PCU53668

**Subject: Mannering Colliery Modification 2 and Chain Valley Colliery
Modification 1**

Please find the following advice provided for proposed modifications to Mannering Colliery (MP06_0311) and Chain Valley Colliery (SSD-5465).

Figure 3: Proposed linkage in relation to existing workings and surface features

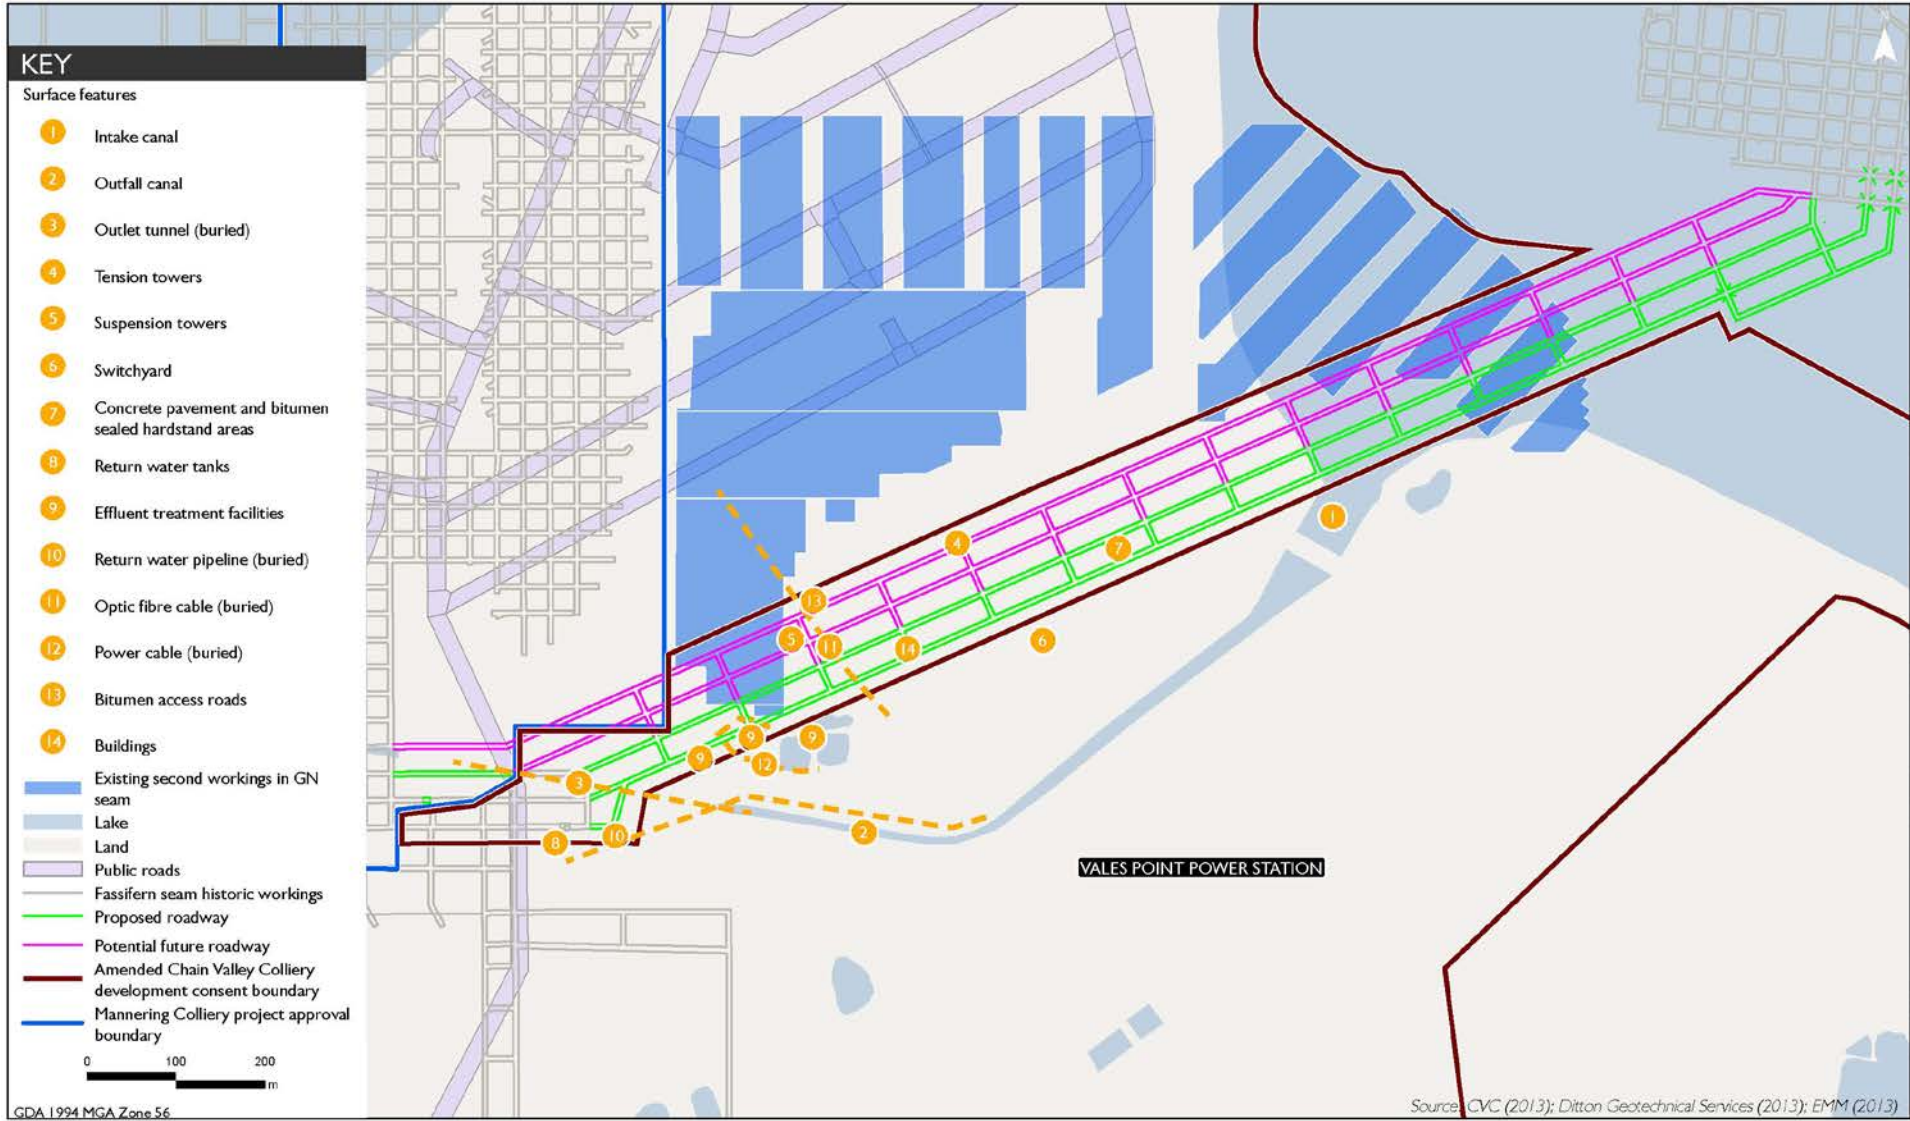
The footprint of the subsidence predicted as a direct result of the proposed roadway, as well as the cumulative effects of the proposed roadway and previous workings, show some impact on land <3m AHD in the vicinity of the lake foreshore and inlet canal. The maximum predicted effect of subsidence is 20mm, but even this small change can alter the distribution foreshore plant of species sensitive to tidal inundation and groundwater such as mangroves, salt marsh and swamp mahogany.

It is desirable to reduce subsidence in the vicinity of the lake foreshore as much as possible.

The effect of direct subsidence (Fig 5.2), and the cumulative effect of subsidence beneath previous workings (Fig 5.3) could be reduced by withholding approval for the additional northern roadways, particularly as the cumulative impacts are biased towards the northern side of the development as a result of the existing workings
